Department of Transportation

Traffic & Safety - Permits Unit

US-24G (E-X) | Peterson Rd
El Paso County

RE: Cimarron Hills Southeast Mixed-Use Filing No. 1 (SF2420)

SUBDIVISION CONCEPT PLAN

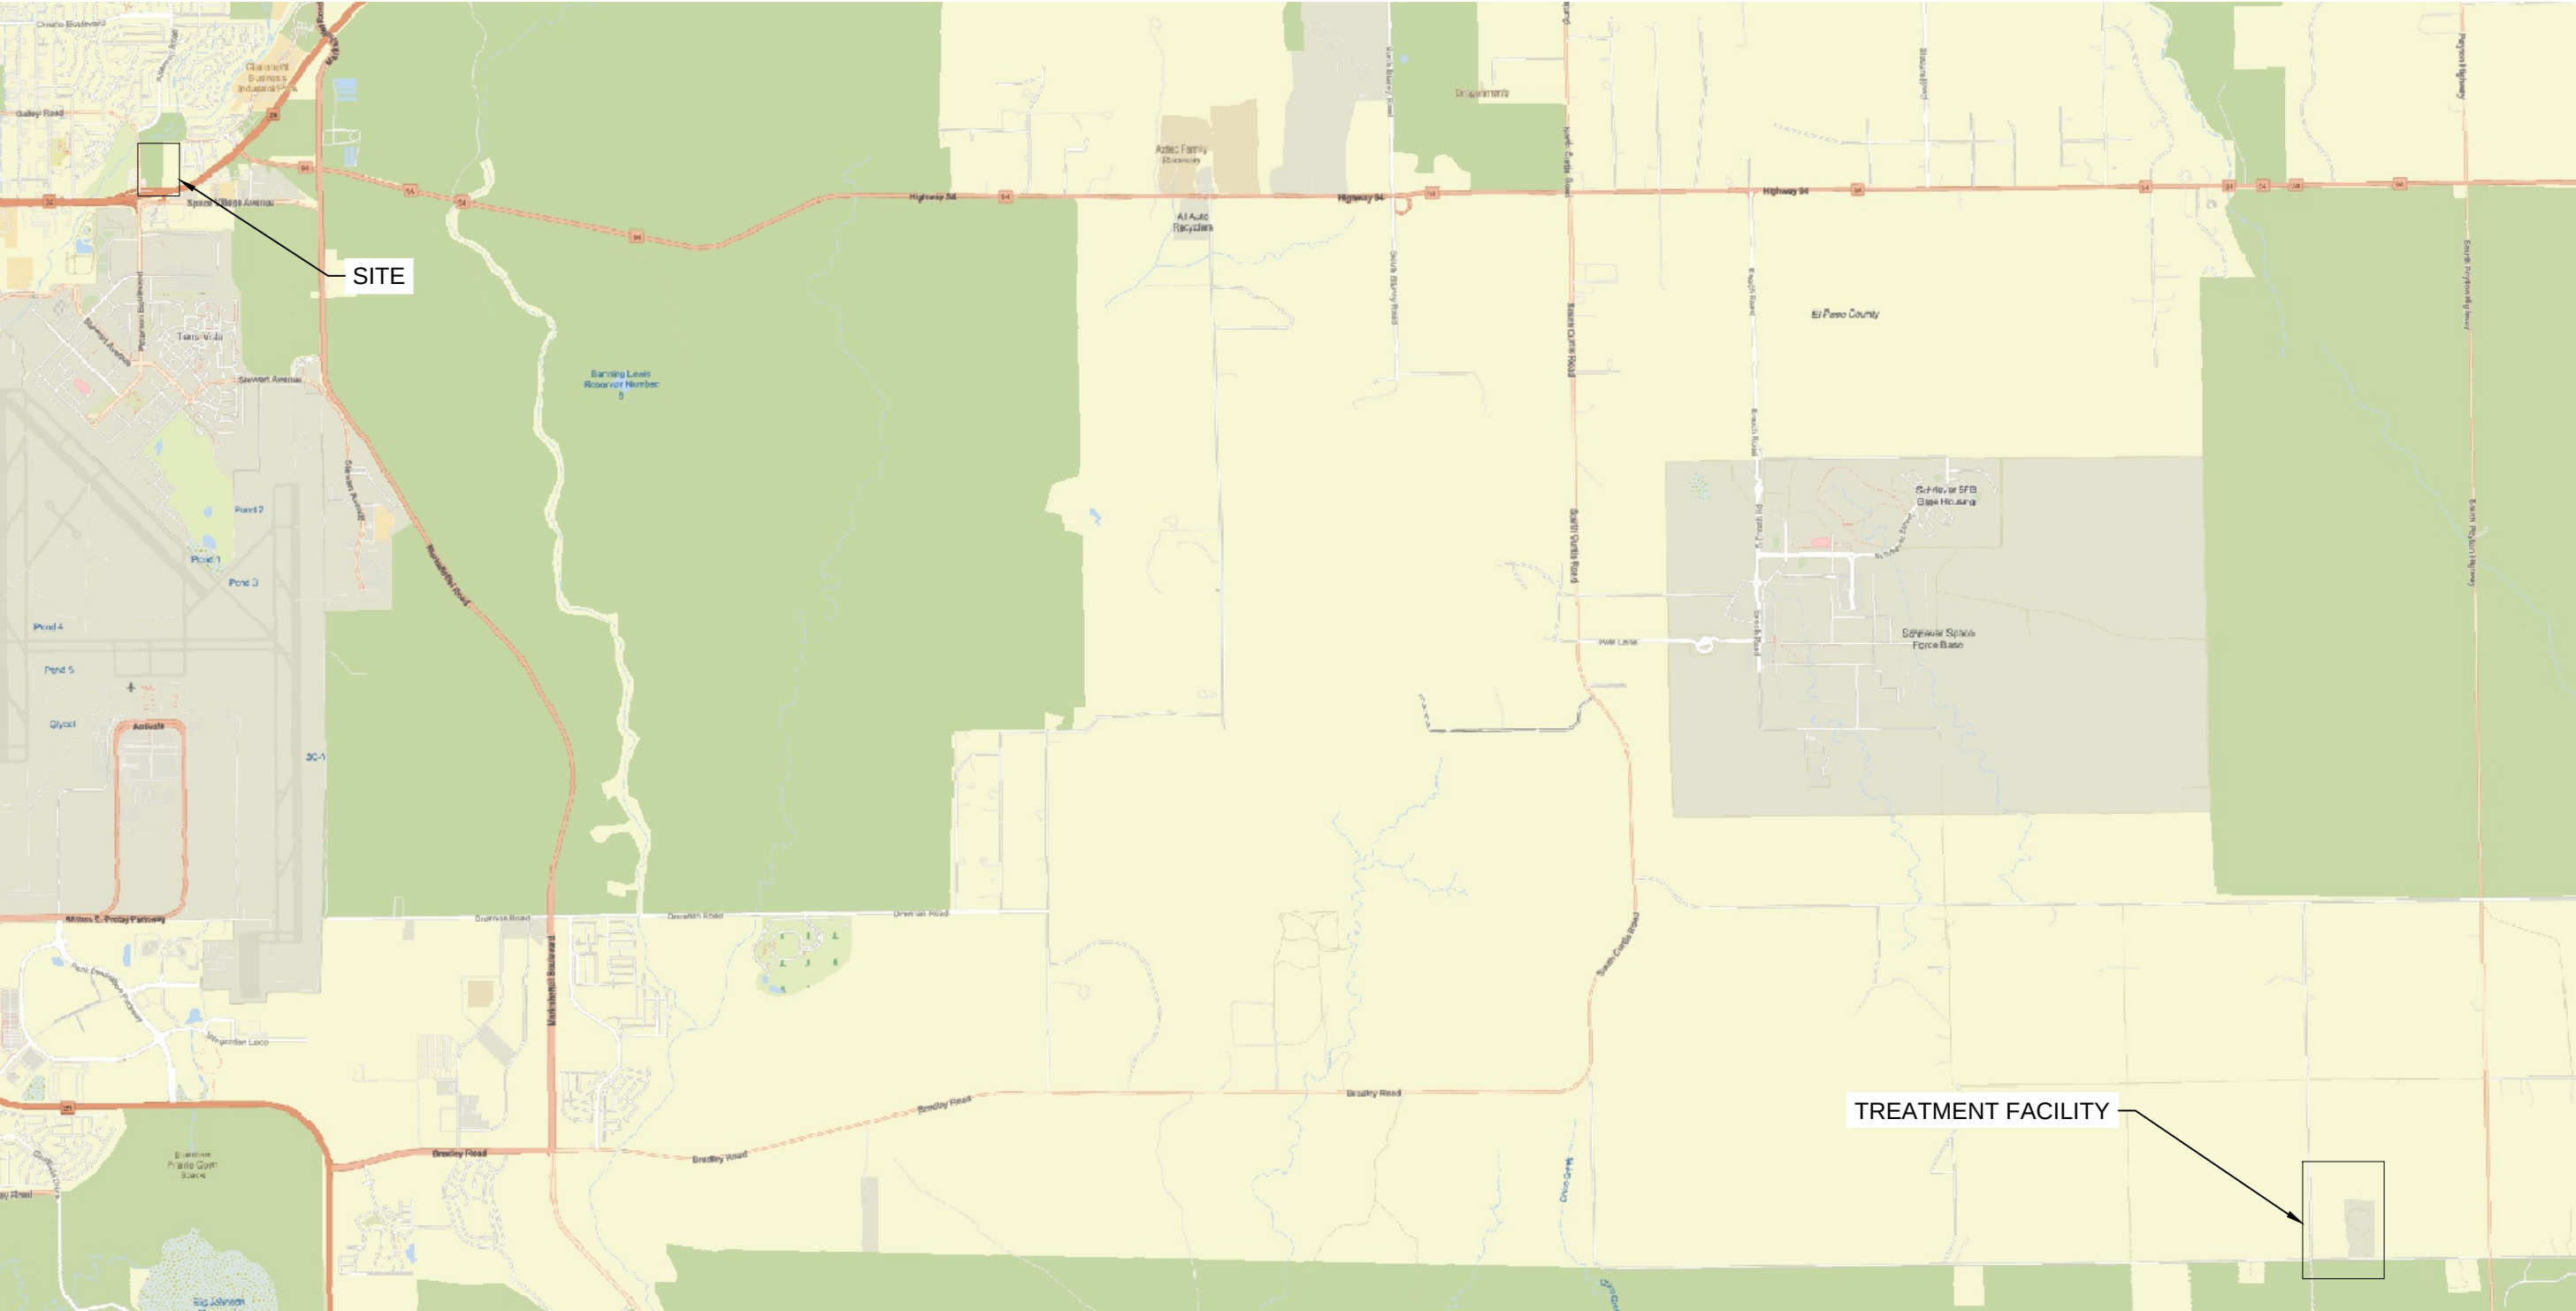
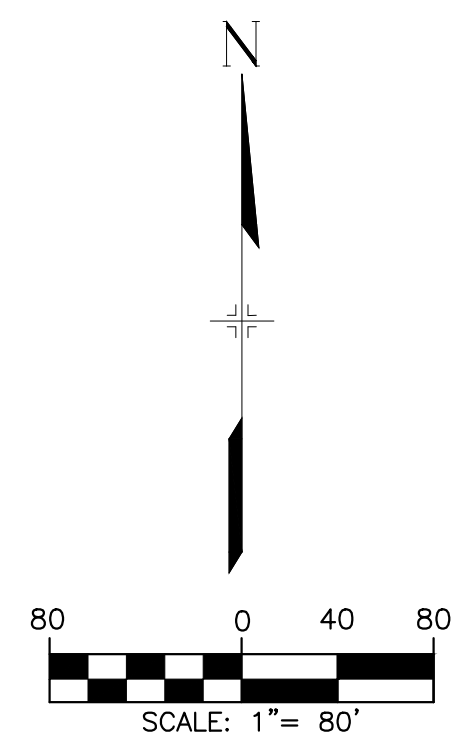
- The existing access is ±275 feet north of the off-ramp terminal from US-24G. Therefore, the existing cross-over at Panamint Court shall be eliminated and median constructed across, or the existing access shall be relocated to the north to meet the minimum distance requirements. This will require some cross-access easements and agreements between the parcels.

- Our previous comments noted that the access for the existing hotel (Panamint Court) is ±275 feet north of the off-ramp terminal from US-24G. Therefore, the existing cross-over at Panamint Court shall be eliminated and median constructed across, or the existing access shall be relocated to the north to meet the minimum distance requirements. This will require some cross-access easements and agreements between the parcels.

CDOT will need to review and approve construction plans for the median closure or access conversion to right-in/right out. These plans shall be submitted with the access permit application.
